Your Ref: 2025/90889

1st April 2026

Former Combs Hostel, Hall Lane, Thornhill, Dewsbury – (KIRK) Demolition of existing hostel and erection of residential development comprising 34 dwellings

EXISTING SEWER PLAN

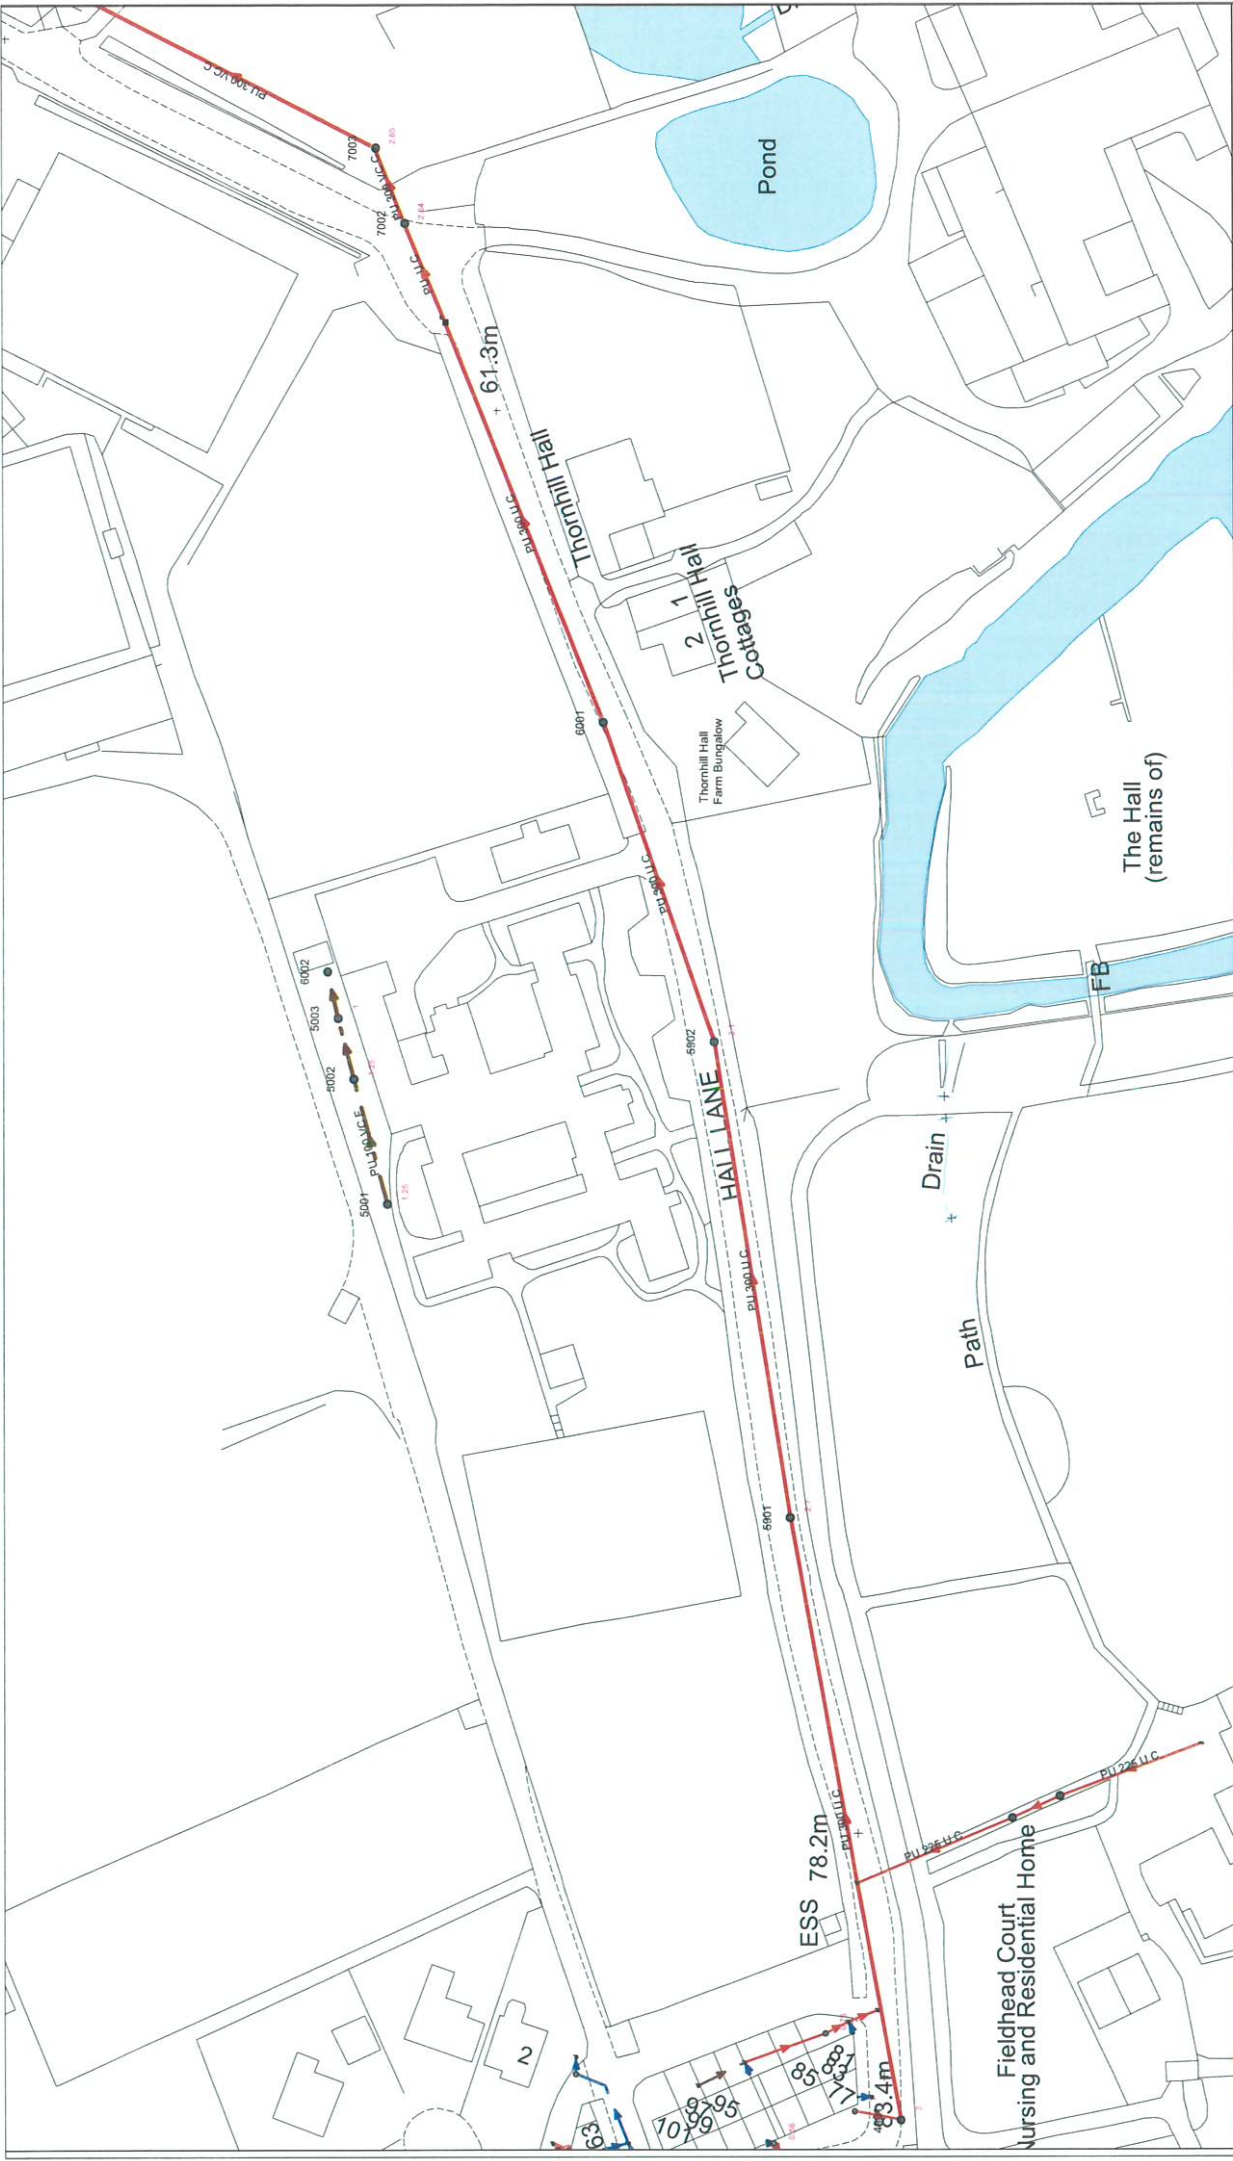
2) On the Statutory Sewer Map, there is a 100 mm diameter public foul sewer recorded to cross the site. It is essential that the presence of this infrastructure is taken into account in the design of the scheme.

a) It may not be acceptable to raise or lower ground levels over the sewer and we will not accept any inspection chambers on the sewer to be built over.

b) In this instance, Yorkshire Water would look for this matter to be controlled (by Requirement H4 of the Building Regulations 2010).

c) A proposal by the developer to alter/divert a public sewer will be subject to Yorkshire Water's requirements and formal procedure in accordance with Section 185 Water Industry Act 1991.

Preliminary drainage layout if SUDs are unsuitable following site investigation for approval only.

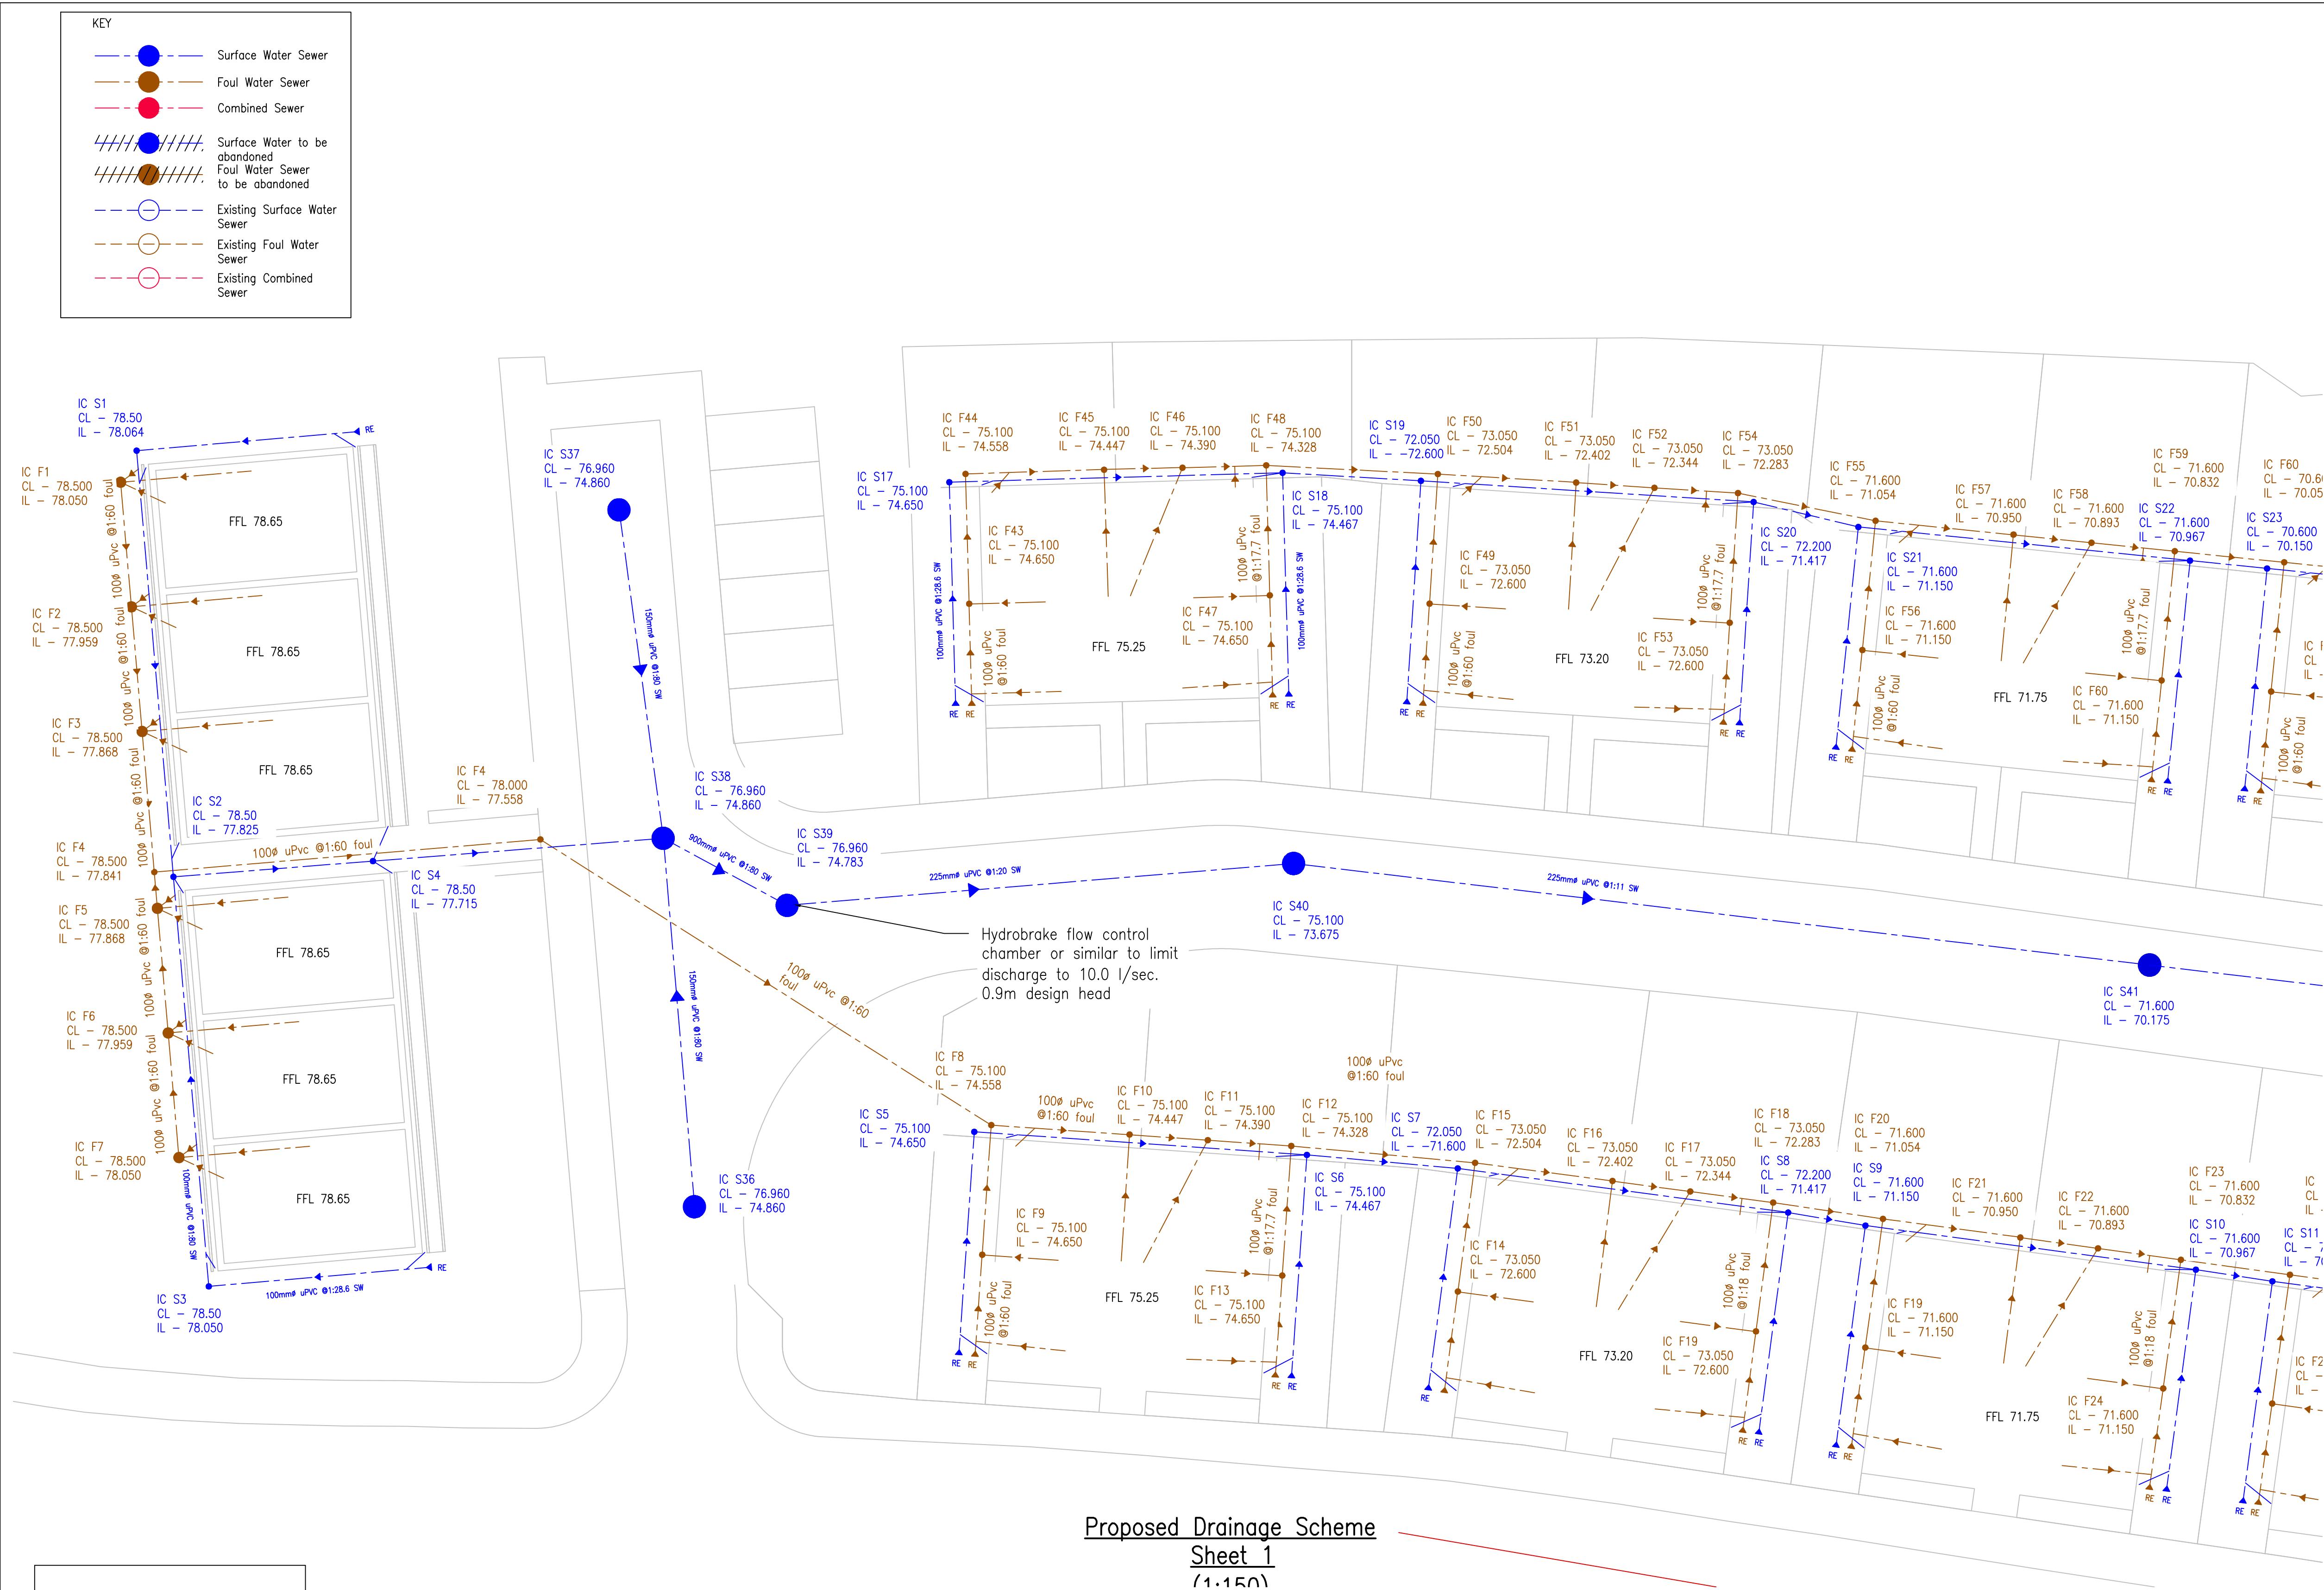
1) The drainage details submitted on drawings D01 (revision C) and D02 (revision A) dated 21/09/2021 that have been prepared by Holdgate Consulting require amendments. The following point should be addressed:

a) evidence should be submitted to show that other (than discharge to public sewer) means of surface water disposal have been considered and why they have been discounted

b) evidence of existing impermeable areas positively draining to the public sewer is required to prove rate of discharge
